## KITTITAS COUNTY DEPARTMENT OF PUBLIC WORKS

**FROM:** Mark R. Cook, Director

**RE:** Hyak PUD Final Development Plan

DEVELOPMENT, STORMWATER AND PARKING PLAN - PARCEL A

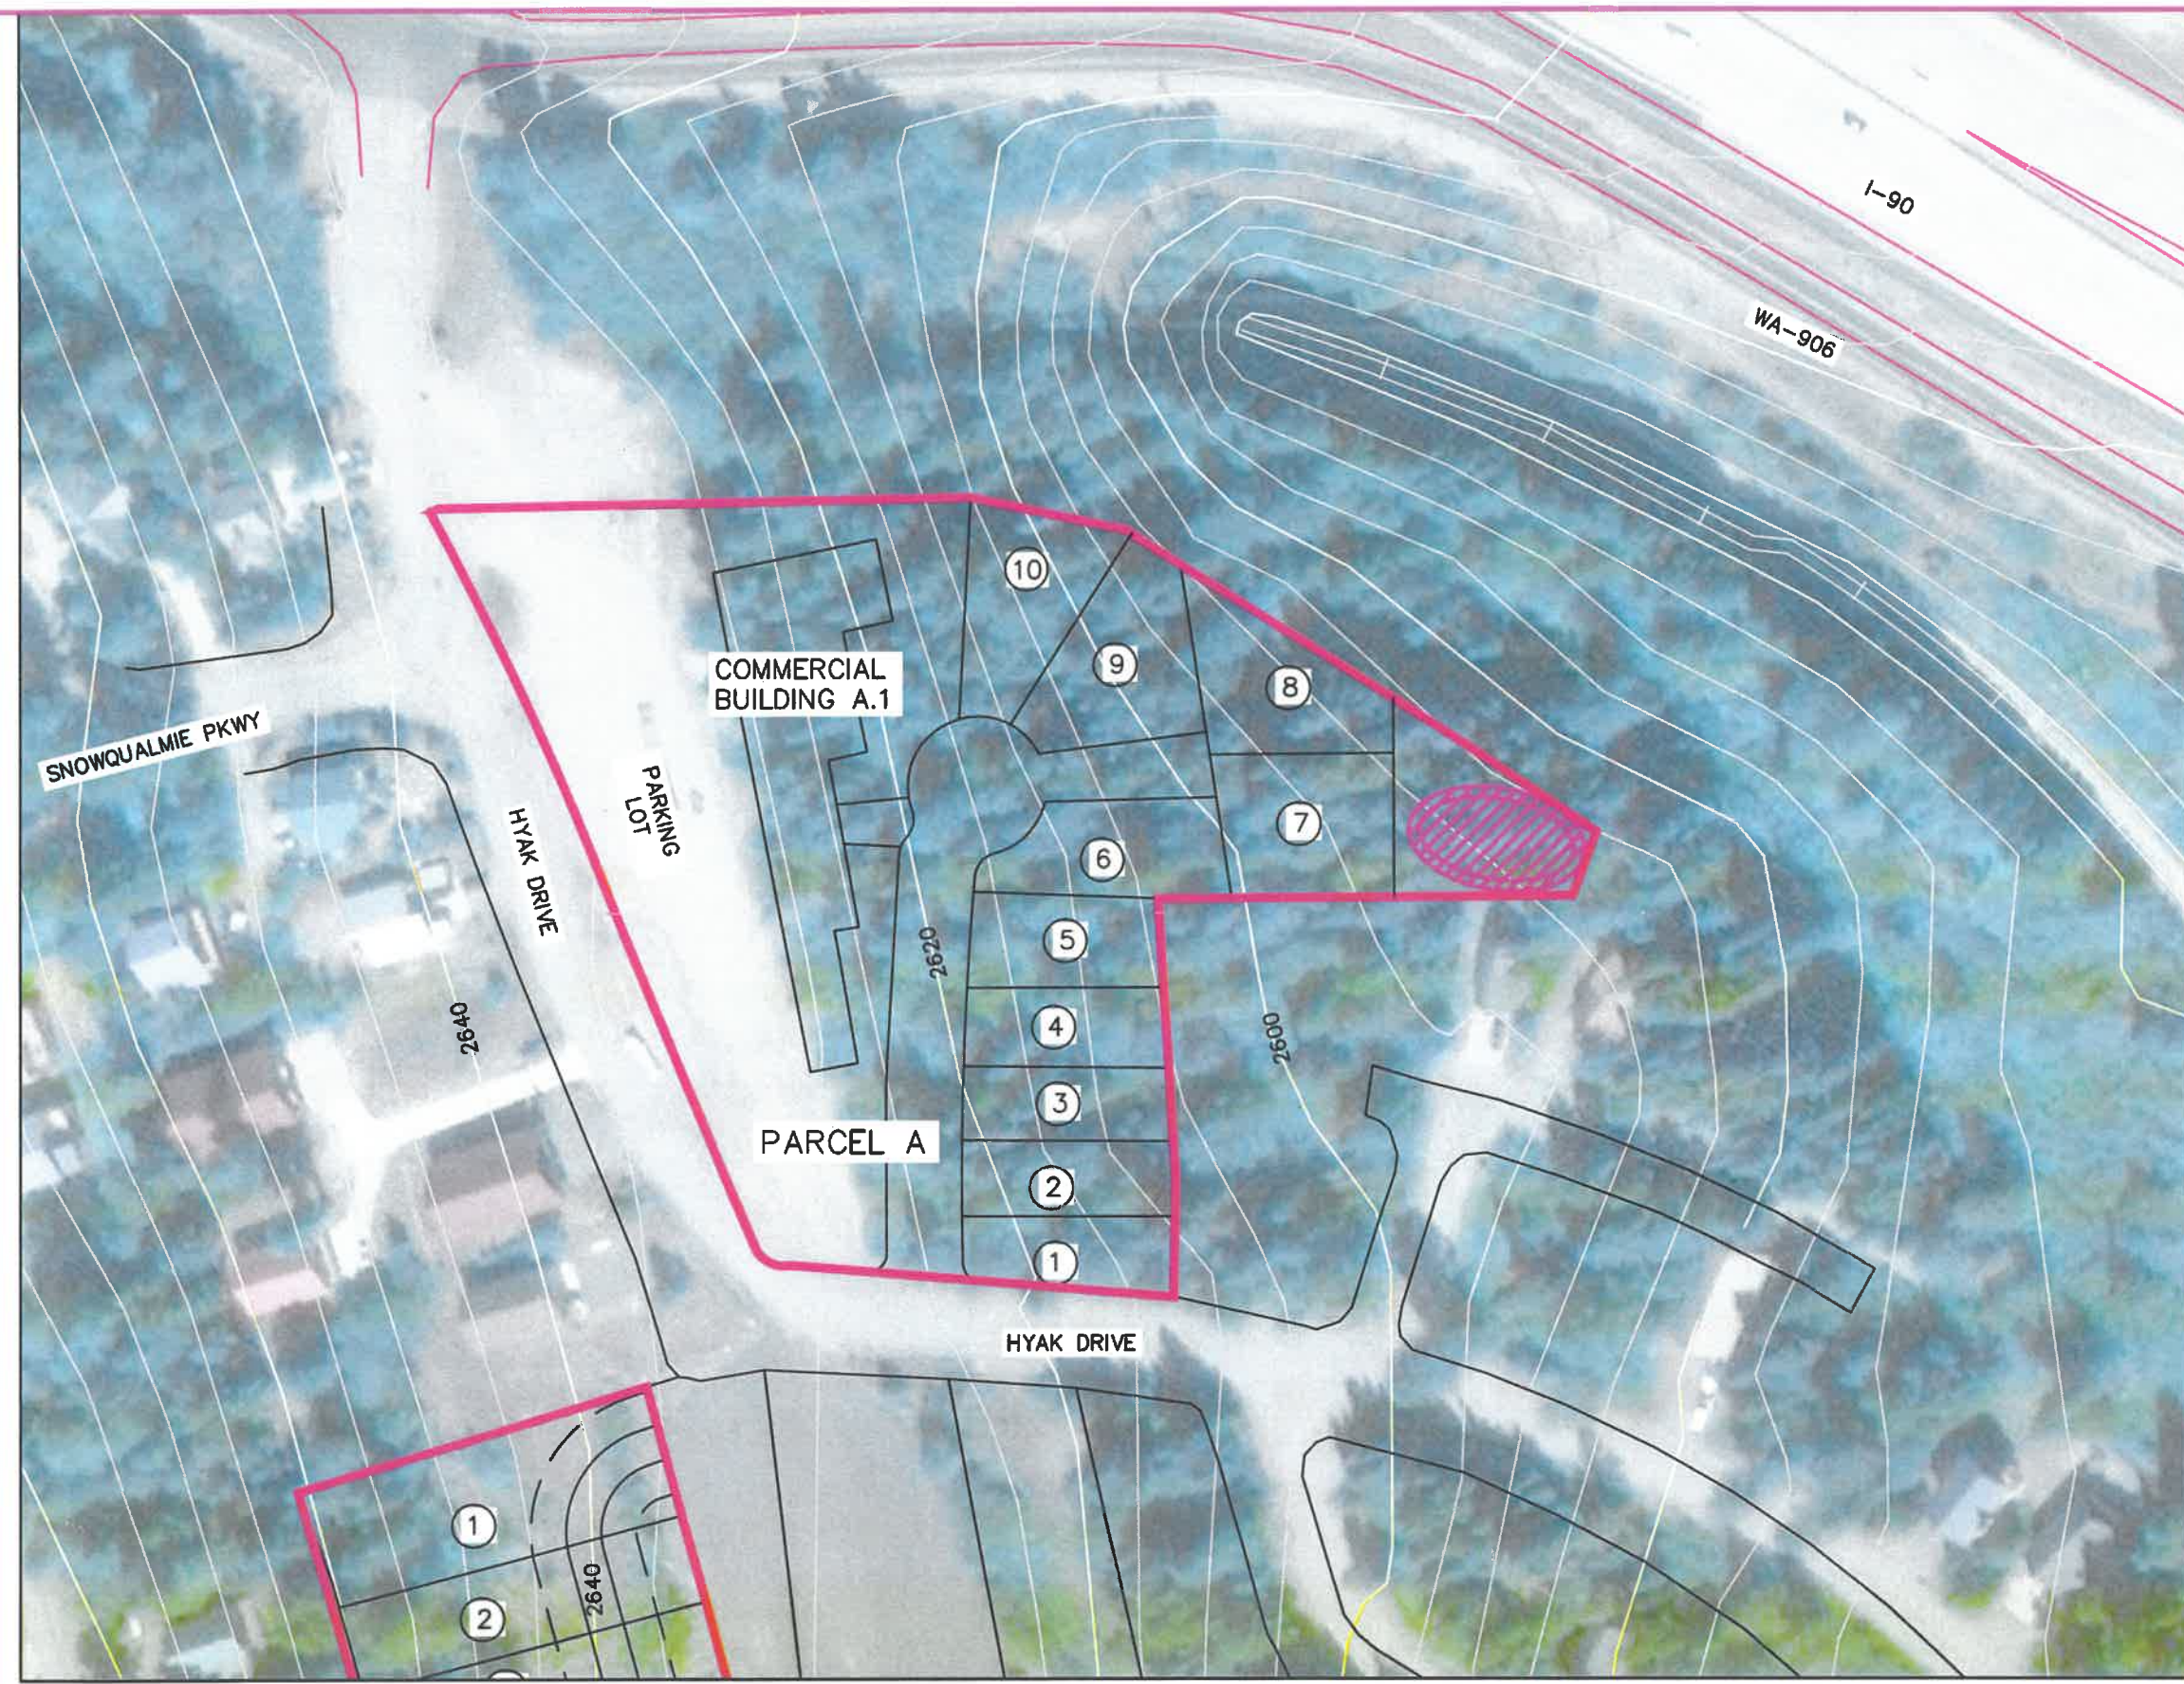
3. The proposed 25 underground parking stalls supporting the commercial use element in Parcel A (20,000 SF) is inconsistent with ITE data on commercial uses generating travel demand. A commercial apparel store is estimated to develop and average of 4 trips per peak hour per 1,000 SF. This suggests a potential of 80 peak hour trips with only 25 parking stalls. The developer is encouraged to refine the commercial land use proposal and provide sufficient parking supporting the actual commercial use. Specific parking demand will be evaluated during final plat submittal.

5. Stormwater treatment and storage prior to discharge are significant issues in Hyak. The terrain is not conducive to large facility size. Attempting to site a storage pond on a side slope creates issues associated with compacted fill on the downslope side of the pond. The suggested size of the majority of stormwater ponds (Parcels: A, B and F) appears to be problematic given the terrain of Hyak.

**DEVELOPMENT, STORMWATER AND
 PARKING PLAN - PARCEL B**

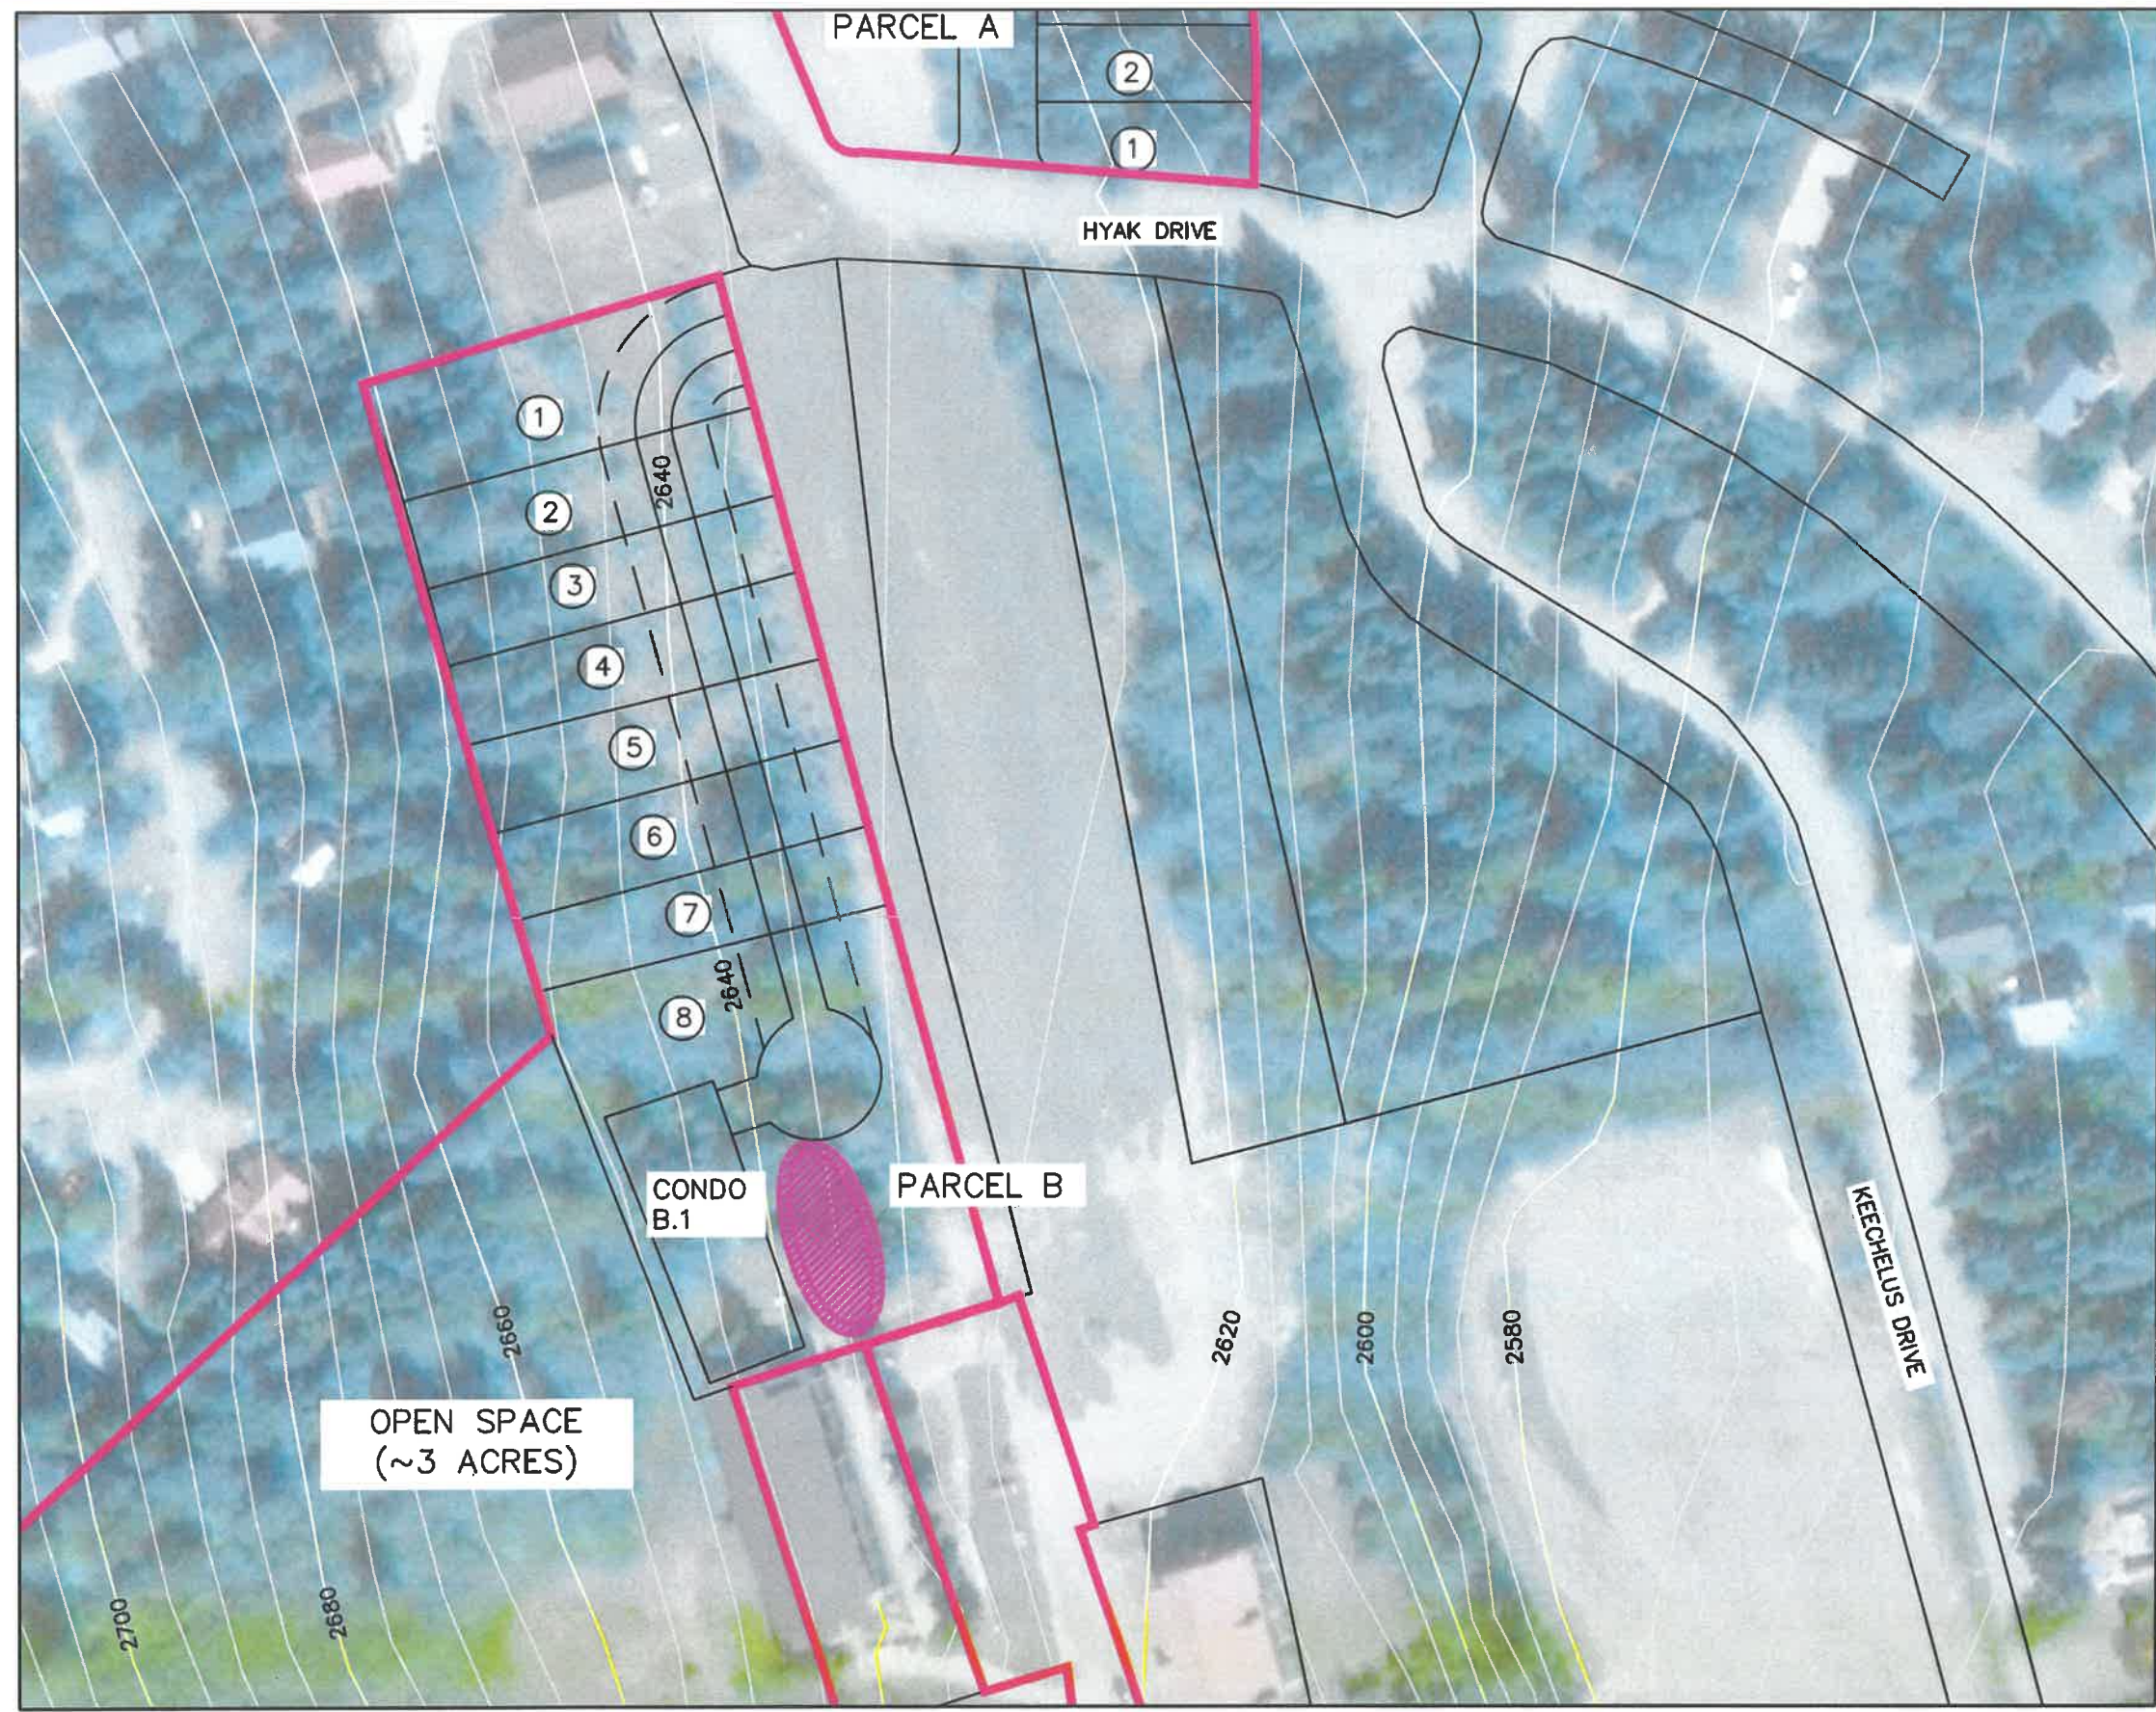
2. Winter parking continues to burden Public Works and the Hyak Community. A single parking stall per condominium is likely insufficient addressing adequate parking for the proposed condominium units. The Institute of Transportation Engineers (ITE) Trip Generation, 7<sup>th</sup> Edition, land use code 230 suggests the trip generation per dwelling unit (residential condominium/townhouse) average rate to be 5.86 per weekday. Given the nature of the destination, it is reasonable to assume that condo owners will be utilizing more than a single vehicle per condo (visitors). It seems unlikely that a single parking stall per condo unit is adequate for managing offsite parking. Any additional parking demand beyond the proposed single stall per condo unit is likely to exacerbate the Hyak parking problem. The developer is encouraged to consider supplemental parking in excess of the proposed single parking stall per condo unit. The parking requirement will be further evaluated during final plat submittal.

Activity Center Parking Table

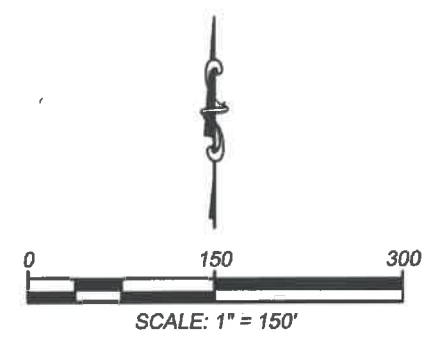
4. The 6,000 SF proposed activity center in Parcel E proposes 20 parking stalls. ITE suggests as many as 90 weekday trips based on land use code 435. 12 peak hour trips are also identified. The activity center has the benefit of being able to refuse patrons; the

developer is encouraged to revisit the number of proposed parking stalls. The specific parking demand will be evaluated during final plat submittal.
